Application Reference: 2026/0499

Site Address: 385 Darton Lane, Mapplewell, Barnsley, S75 6AL

Proposal: First floor rear extension, and alterations to roofline on side (above integrated garage) of dwelling.

Proposed Roof Plan
1 : 50

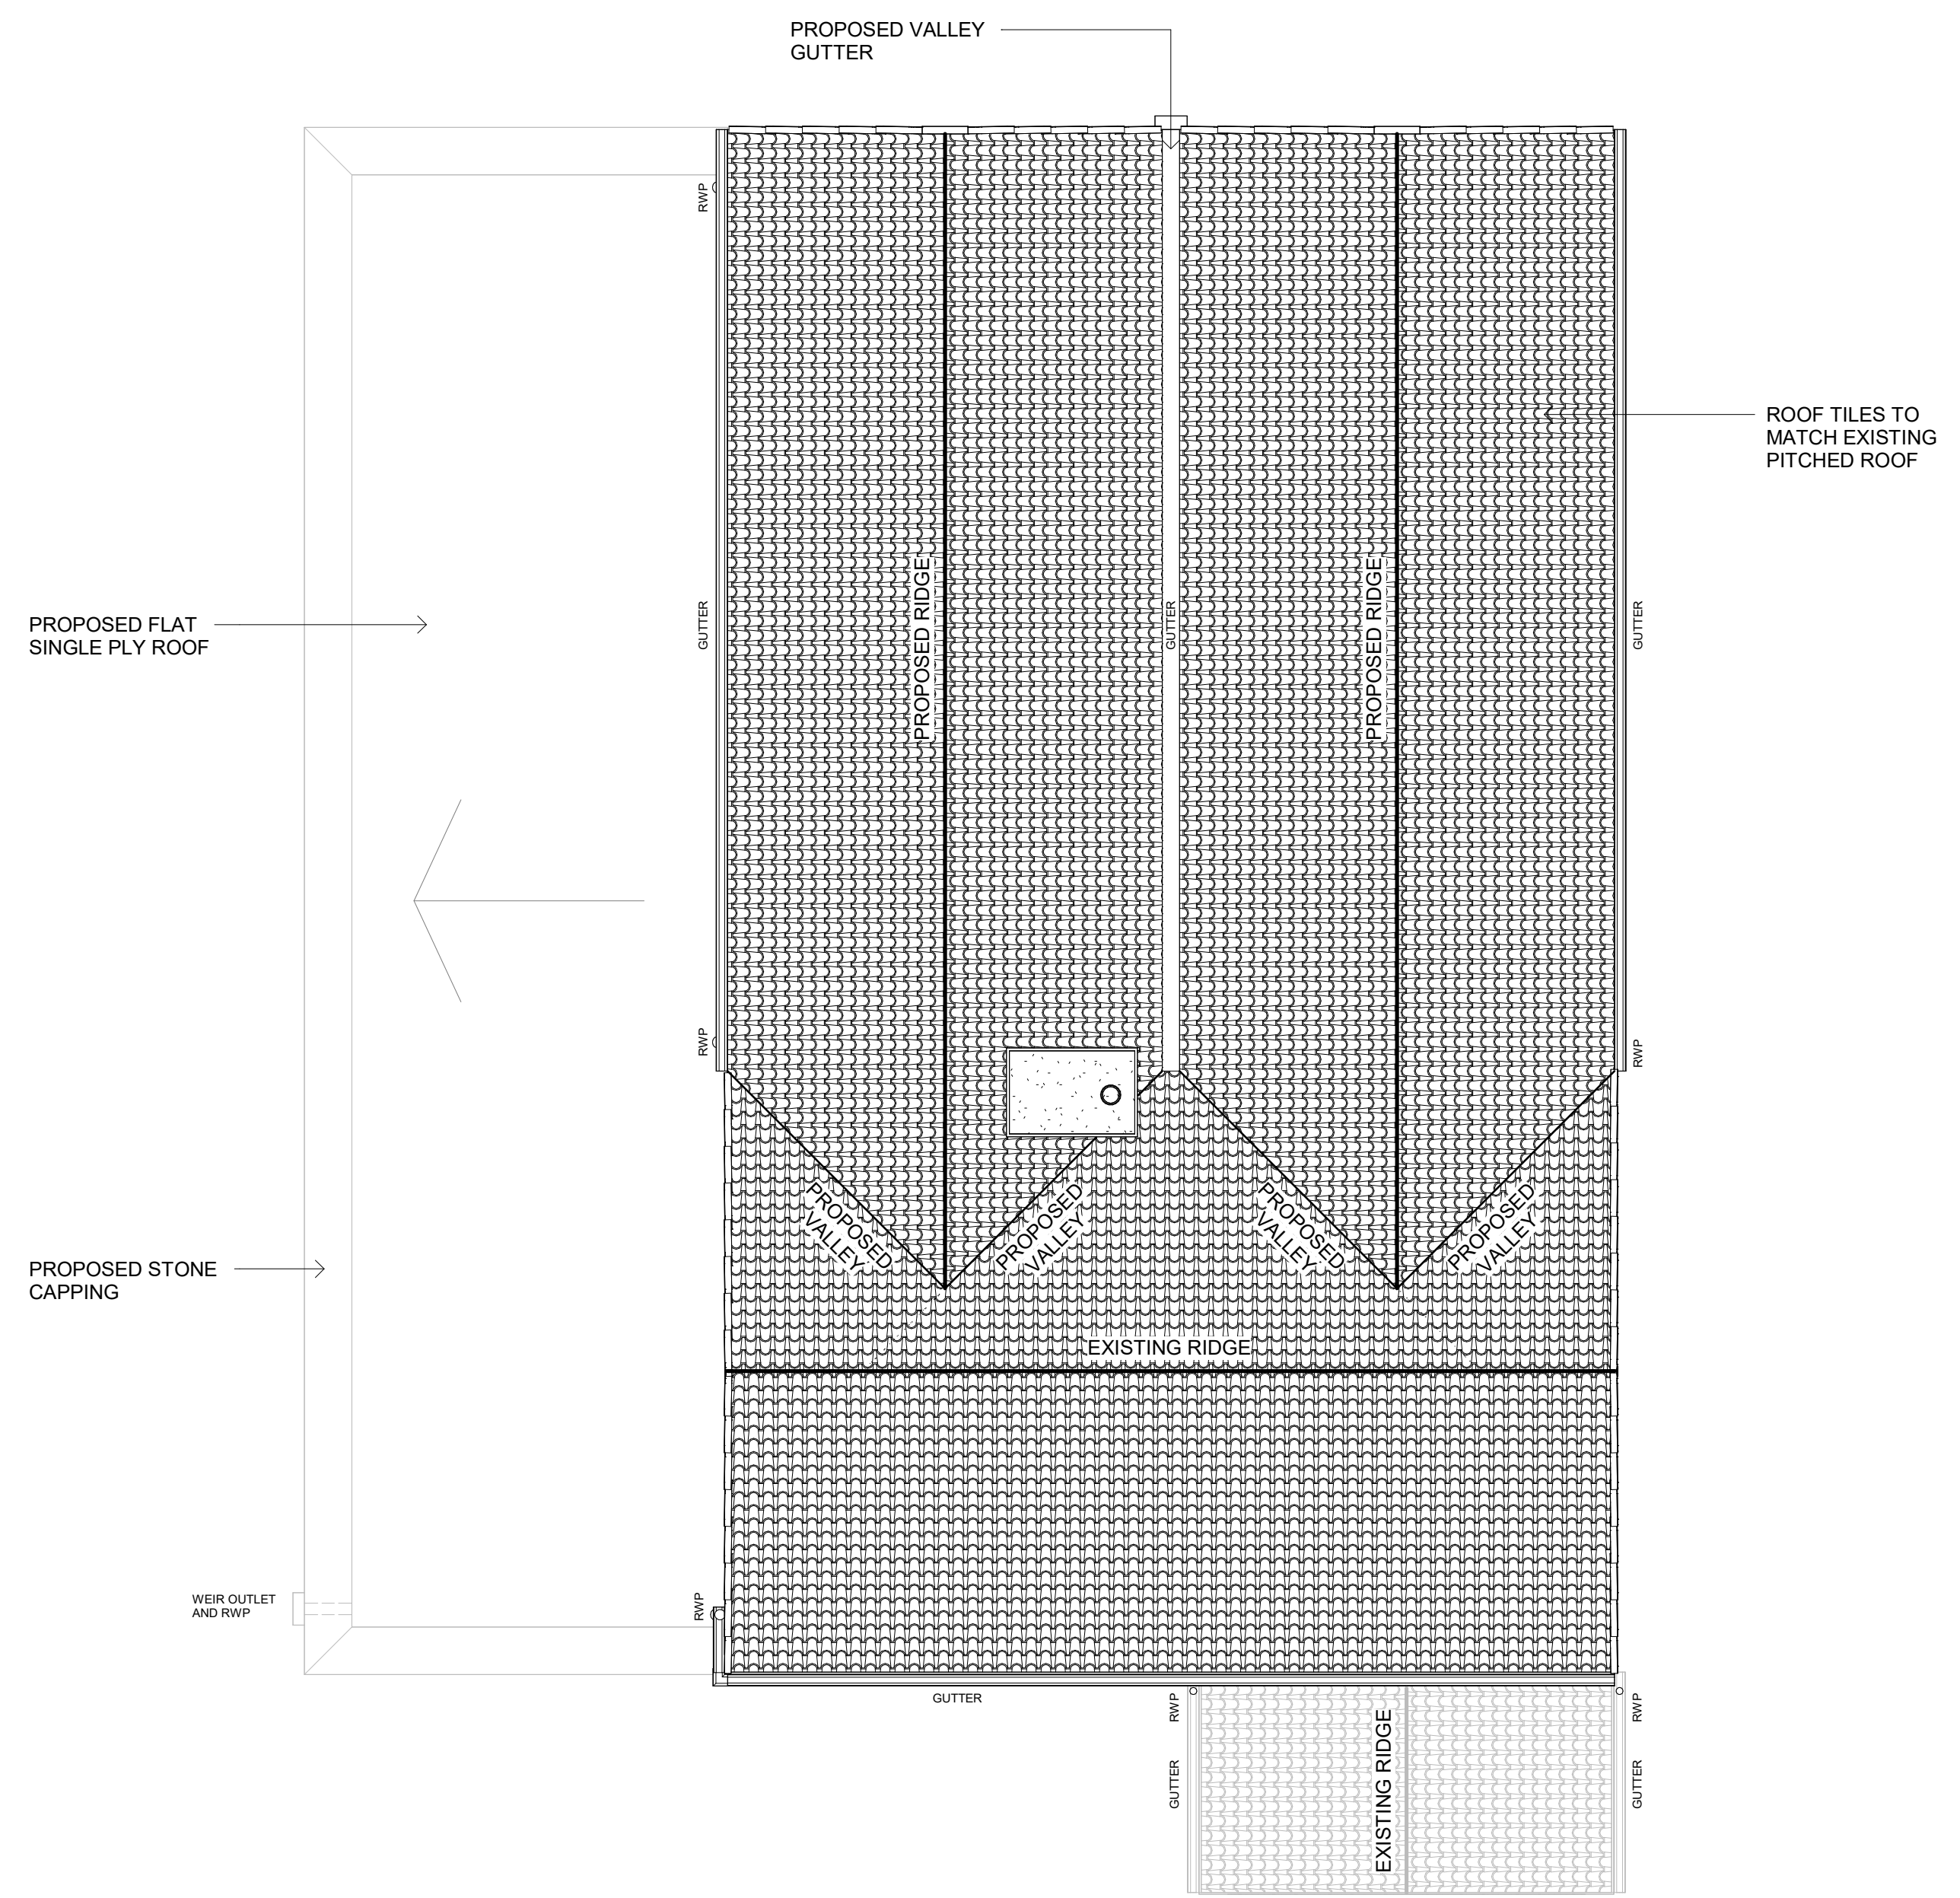
The greater scale and massing which the proposal would create is acknowledged; however, this is considered to be outweighed by the removal of the existing incongruous first floor roof and the installation of a more appropriate design. The proposed roof would be set down from the existing roof by approximately 0.3 metres and would be screened from the front elevation

The proposed use of a flat parapet roof to be installed on the existing single storey side extension is not preferred, however given the use of a pitched roof would impact upon the proposed first floor side elevations windows, which are imperative to allow for acceptable neighbouring residential amenity, the flat roof is considered acceptable on this occasion. The roof height is also considered modest at 3 metres and remains subordinate to the existing dwelling. It is also acknowledged a similar extension could be erected in the same location with a flat roof under permitted development. It would therefore not be prudent to restrict this element of the proposal.

A cross section showing the 25-degree angle of the property to the proposal was requested from the applicant to assess any overbearing and loss of outlook impact from the proposal. This was received on the 6th August 2026. The proposed flat roof for the side extension was also requested to be amended to a pitched roof. It was communicated the proposed pitch of the roof would impact upon the side elevation windows of the proposal.

**Proposed South East Elevation**  
1 : 50

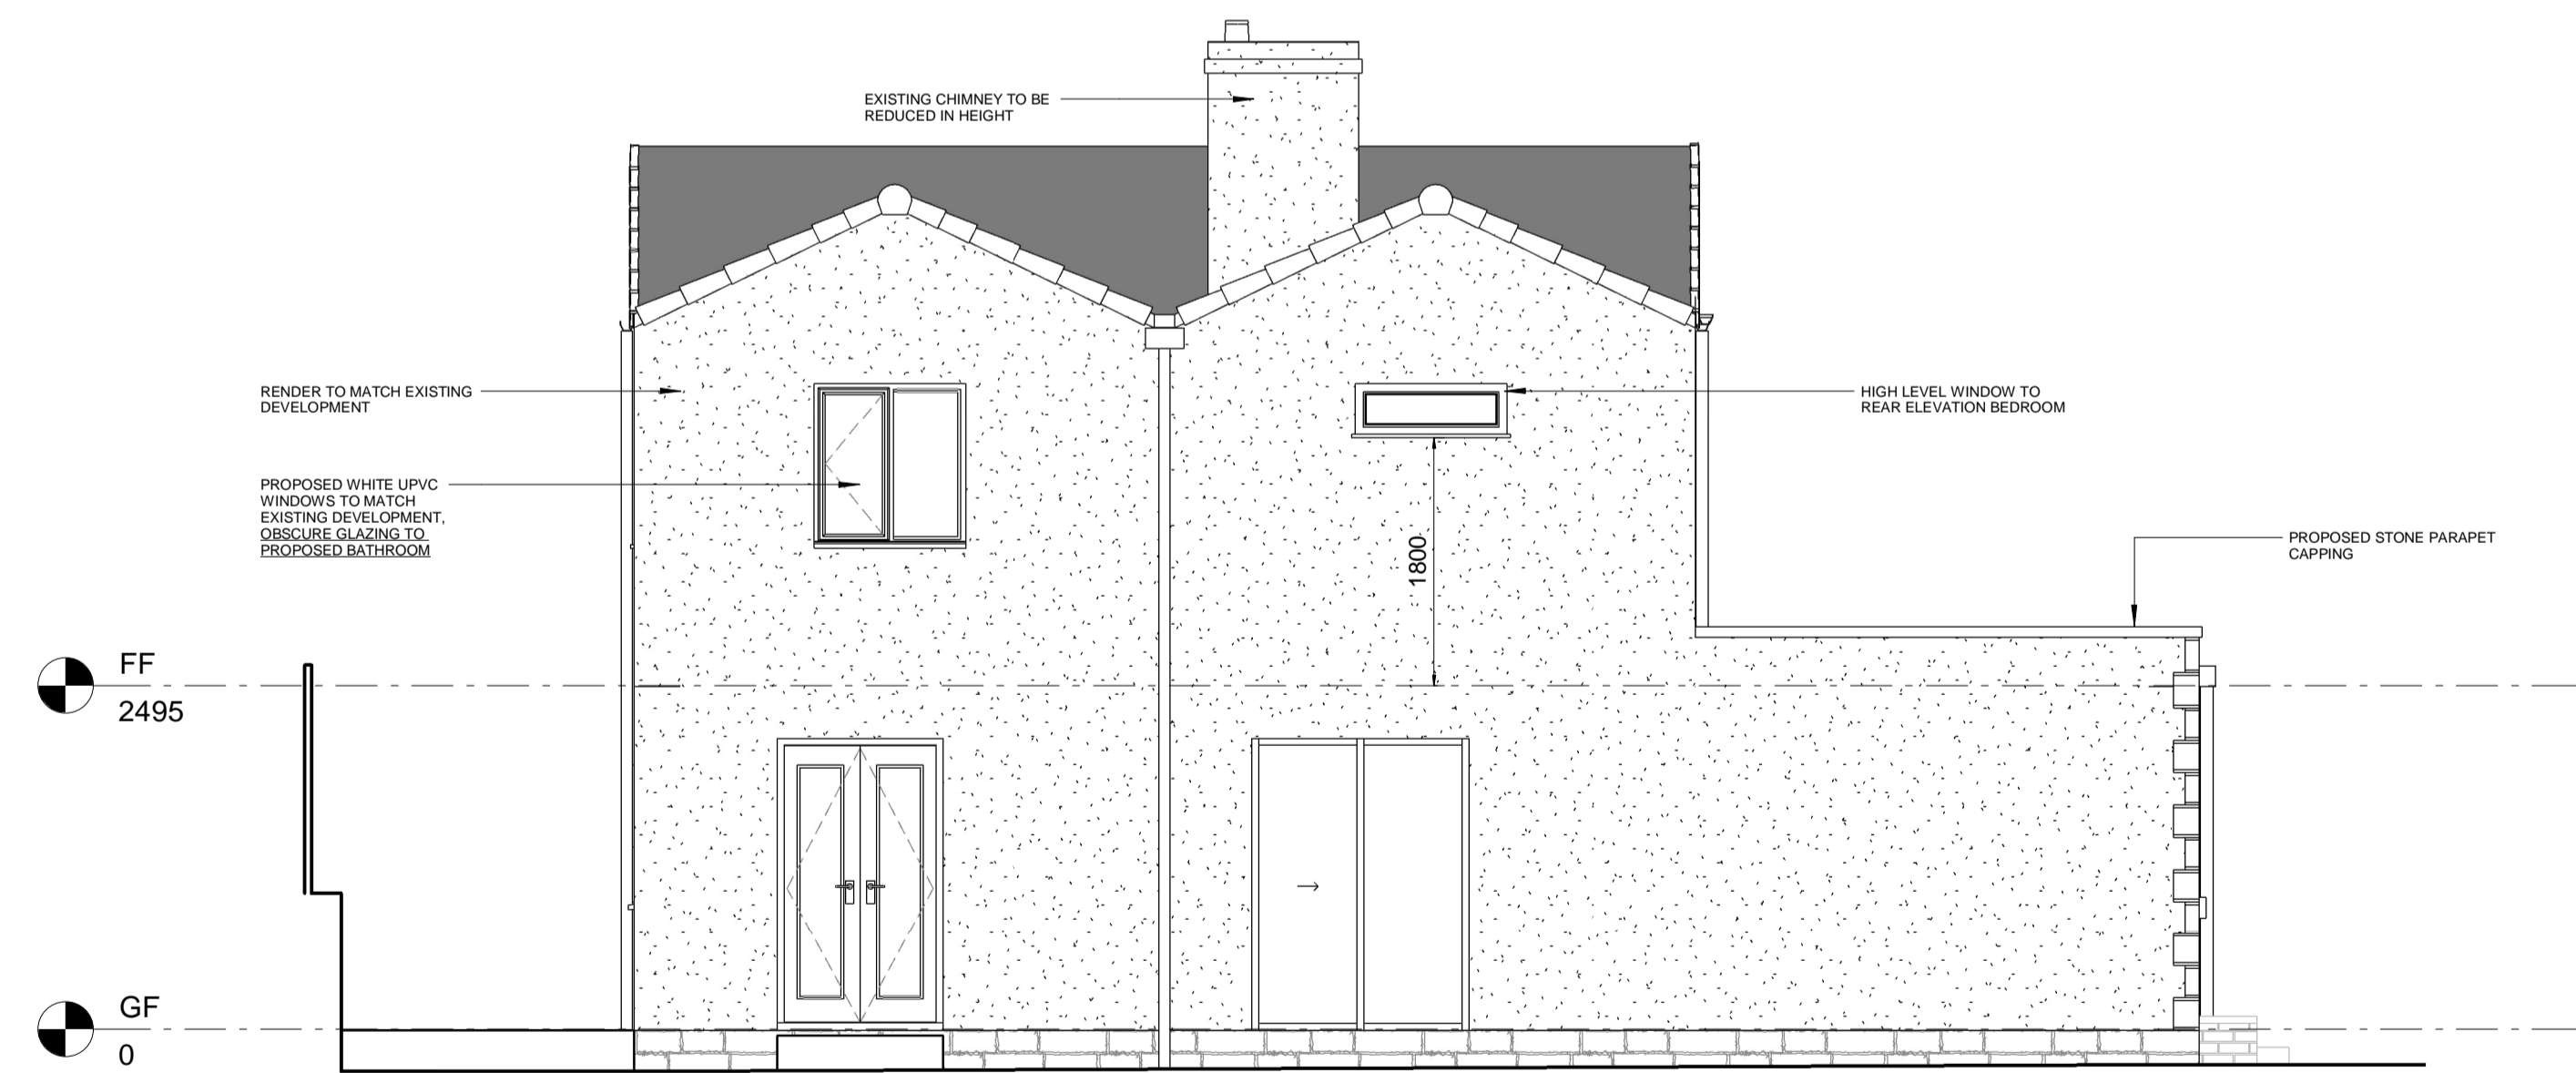
An obscured rear elevation window is proposed at first floor level to the east of the rear elevation servicing a bathroom. A high-level window is proposed to the west of the rear elevation to service a bedroom. A window is proposed at first floor level to each side elevation servicing a bedroom.

Although the bathroom window has already been detailed to be obscured, the window will also be conditioned to be obscured in order to protect the privacy of the applicant and the neighbouring properties located to the northwest of the site.

The proposed side elevation windows would service bedrooms. The southwest facing bedroom window would be distanced to 383 Darton Lane by approximately 14 metres and would face a blank elevation resulting in little to no impact on loss of privacy. The proposed northeast facing bedroom window would face the commercial units. The window would mostly face the associated parking for the commercial units and the roof of the units. As such the window would not result in any loss of privacy.

Site GA Section
1 : 50

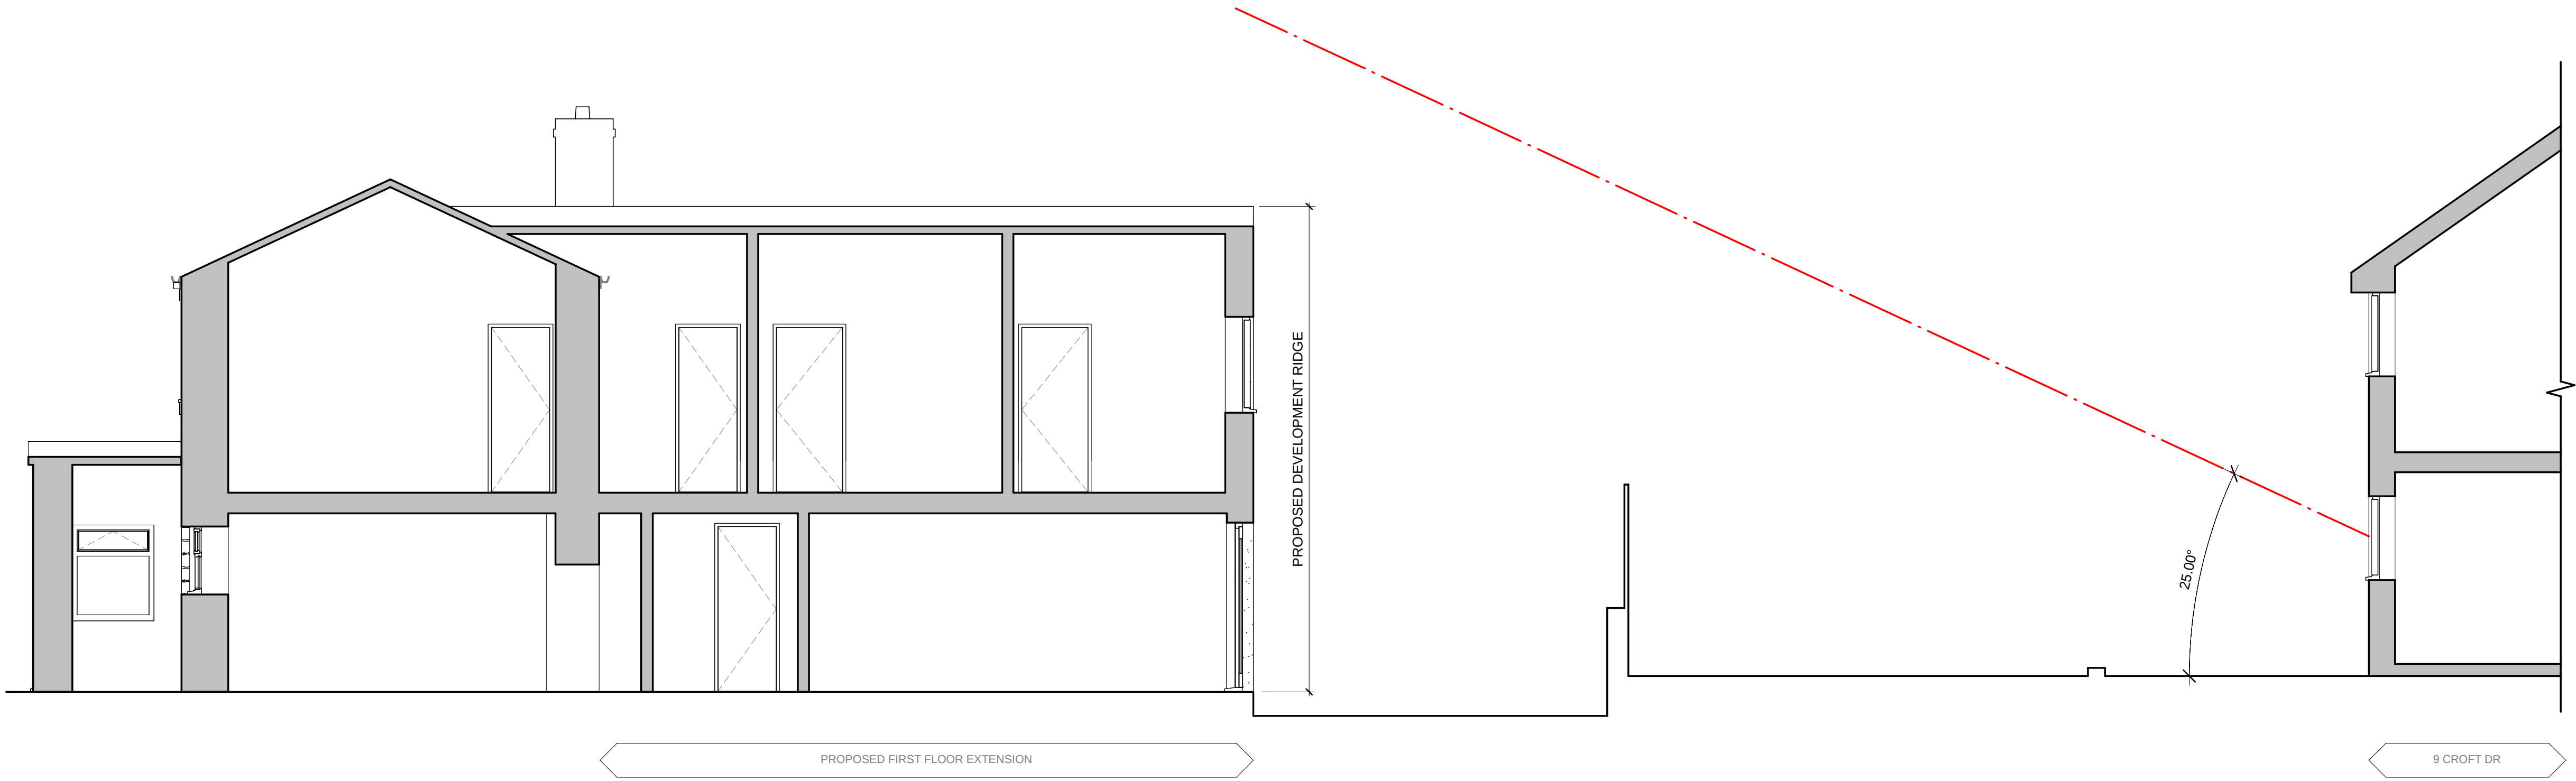
25-degree rule.' Although the proposal is acknowledged to provide a two-storey structure in close proximity to the boundary between the two sites, the proposal would not intersect the 25-degree angle of the rear elevation ground floor window of the rear dwelling. Furthermore, the proposal would be at a reduced height than the existing first floor extension and therefore reduces the overall impact of the proposal. As such, although the proposal would provide some dominance the proposal is not considered to be of a scale which is of a detrimentally overbearing nature.
